## **Response to Planning application from Hertfordshire County Council (T and CP GDP Order 2015)**

District ref: 6/2023/2115/FULL  
HCC ref: WH/18673/2023  
HCC received: 24 October 2023  
Area manager: Manjinder Sehmi  
Case officer: Gideon Gasinu

38 The Ridgeway Cuffley Potters Bar EN6 4AX

Erection of a detached dwelling with new vehicle entrance and crossover and basement

PROJECT: 38 THE RIDGEWAY  
EN6 4AX  
TITLE : VISABILITY SPLAYS  
Date: OCTOBER 2023  
Scale: 1:50/300 AT A1 Drawn: SDK  
**DRAWING NUMBER: 207-213**

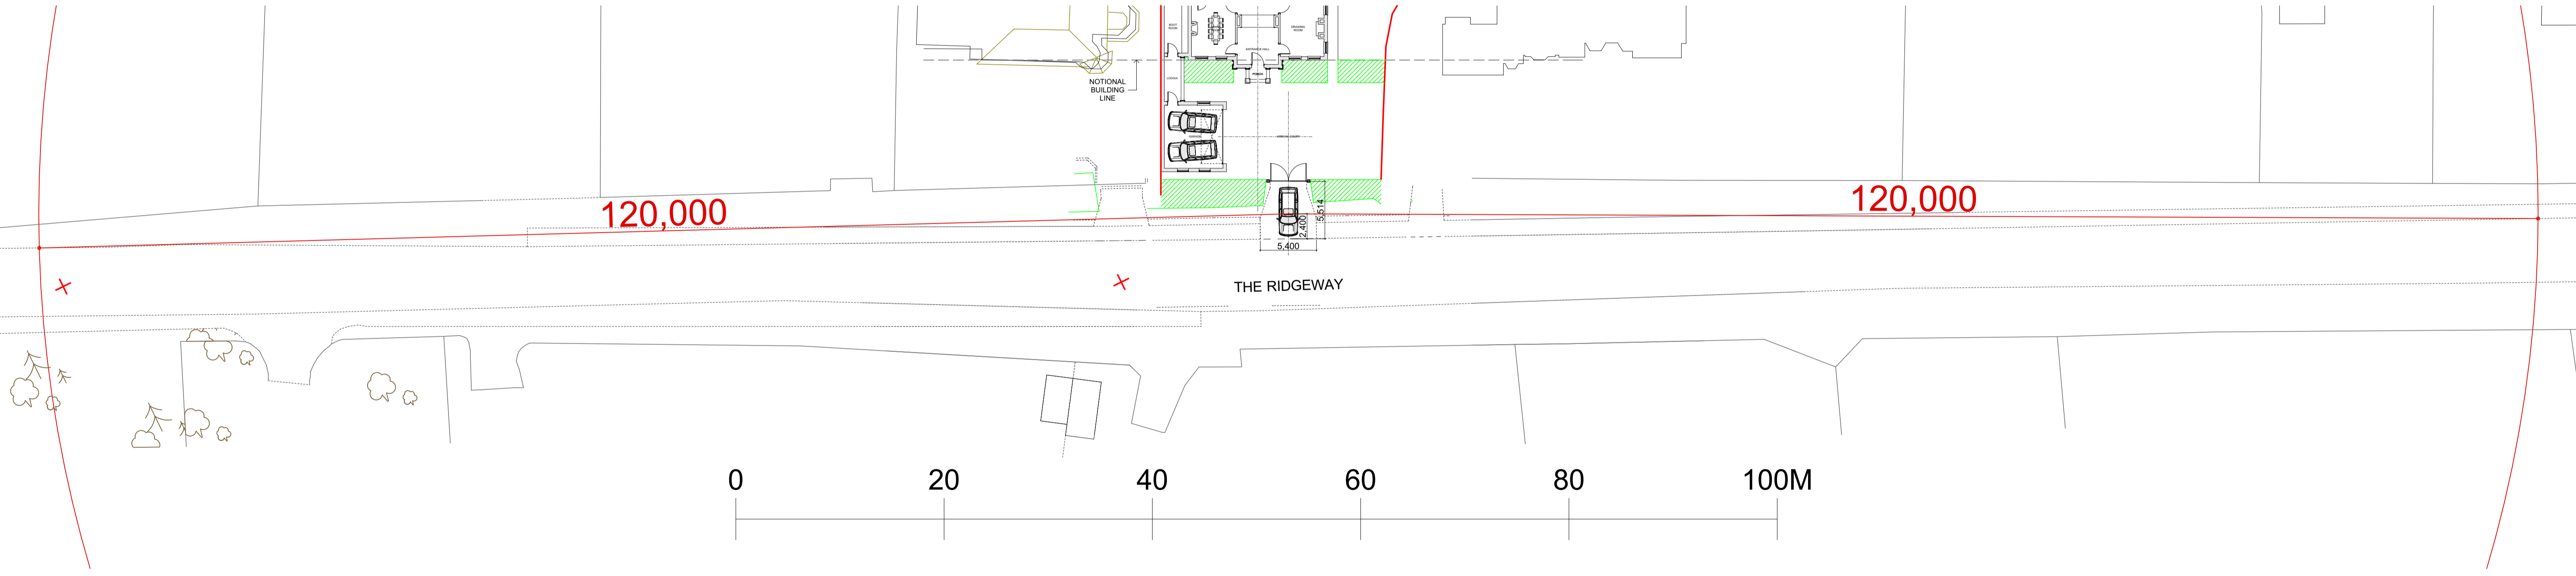
Prior to the first occupation of the development hereby permitted the vehicular access shall be completed and thereafter retained as shown on drawing number 207-213 in accordance with details/specifications to be submitted to and approved in writing by the Local Planning Authority in consultation with the Highway Authority. Prior to use appropriate arrangements shall be made for surface water to be intercepted and disposed of separately so that it does not discharge from or onto the highway carriageway.

Visibility splays from the left and right of the new access has been demonstrated as achievable as shown on 207-213. These splays shall be permanently maintained in each direction, within which there shall be no obstruction to visibility between 600mm and 2.0 metres above the carriageway level.

**DRAWING NUMBER: 207-215**

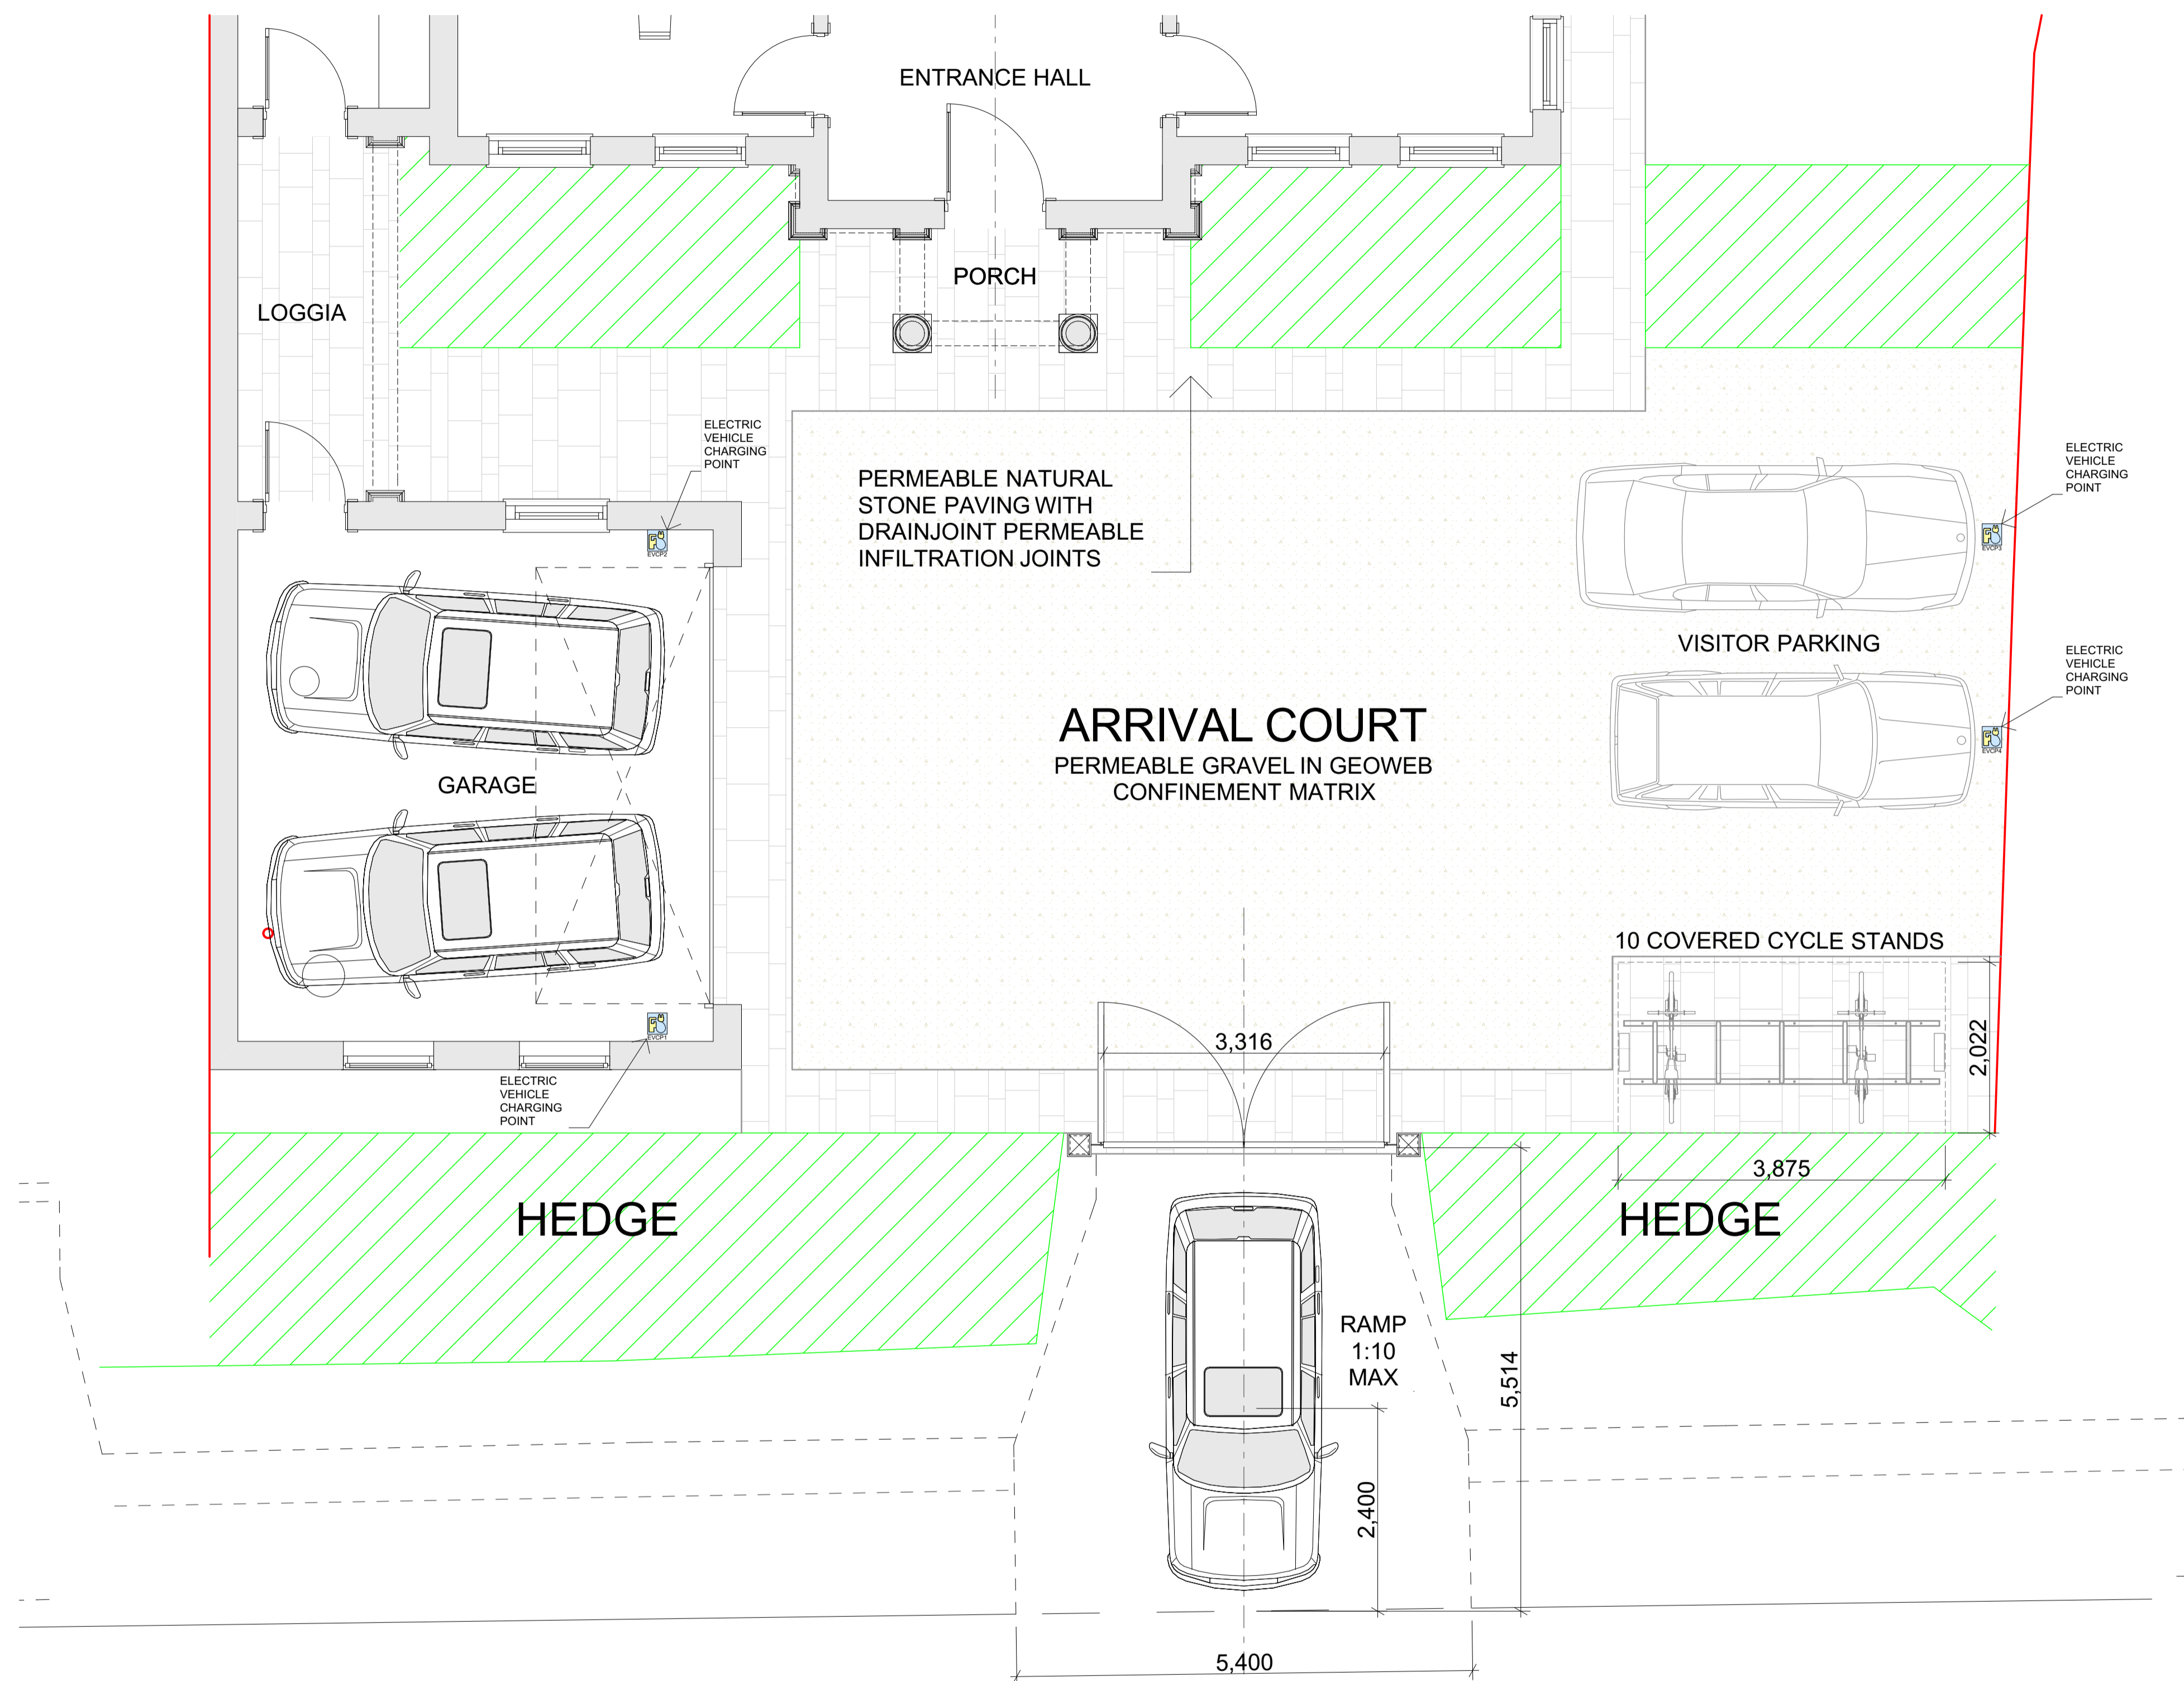
The applicant has indicated on Drawing 207-215, the proposed access arrangement which is considered suitable. The applicant will need to apply for permission and enter into a vehicle crossover agreement with HCC as the Highway Authority. The maximum width allowable is 5.4m for a double crossover.

2 EV charging spaces are proposed which is considered acceptable and 2 additional visitor parking spaces. The parking provision and layout is the responsibility of the LPA to determine the level and suitability of the car parking proposals, however, it is essential that it is operated in efficient and safe manner to minimise the impact on the local highway network which is the responsibility of HCC.
